From: Richard Stefansk [REDACTED]
Sent: 19 June 2018 11:24
To: Pat Aird
Subject: Re: 7 Alleyne Way M37/18/HH

From: Pat Aird <Pat.Aird@arun.gov.uk>
Sent: Thursday, June 14, 2018 3:36 PM
To: Richard Stefanski [REDACTED]
Subject: 7 Alleyne Way M37/18/HH

I have now had the opportunity to assess the above proposal and I have concerns about the potential impact on the amenities of adjoining occupiers in terms of loss of light, outlook and privacy.

PROPOSED EAST ELEVATION

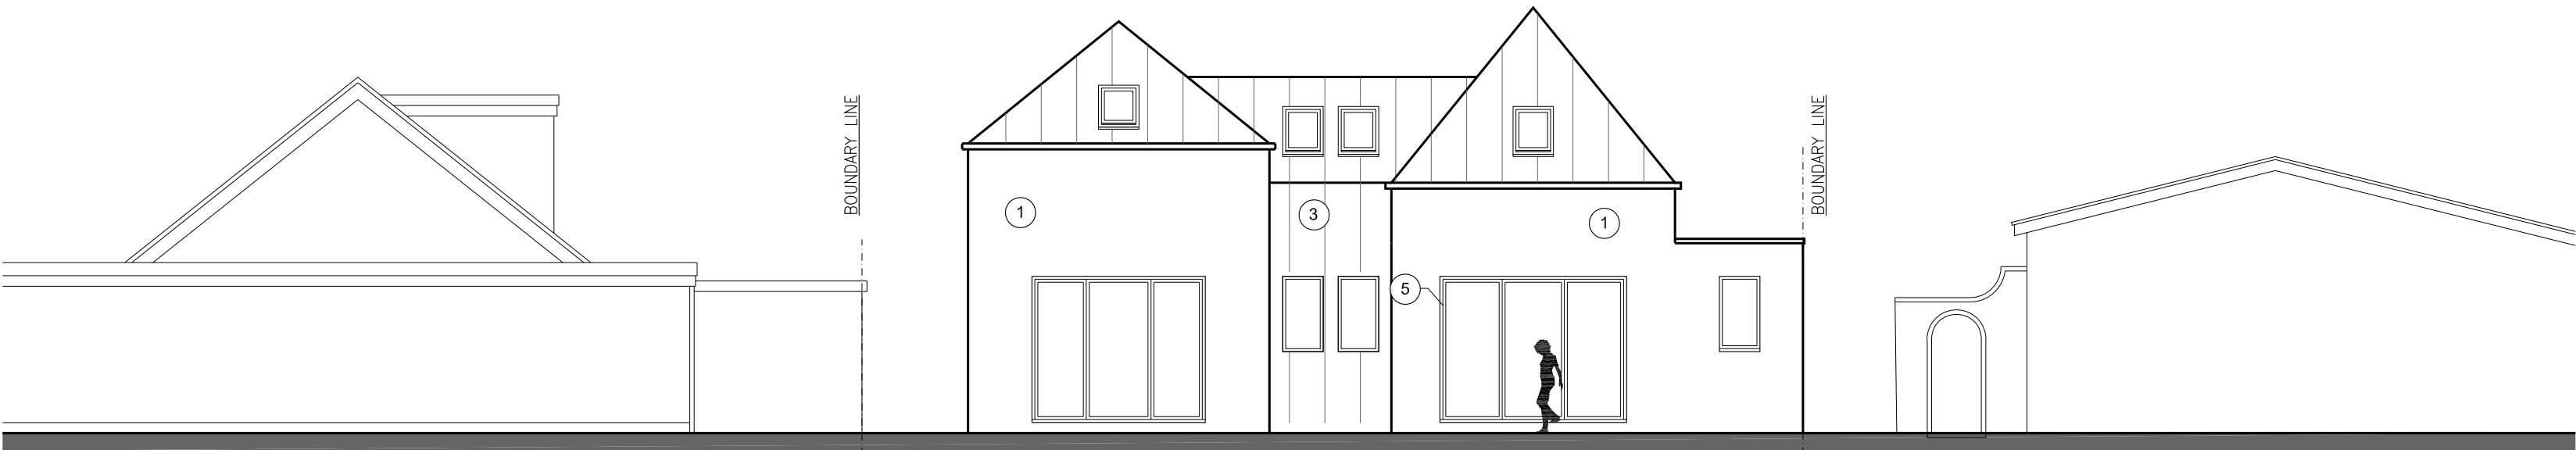
Attached are the updated drawings which show the alteration to the windows at 1st floor level within the east elevation.
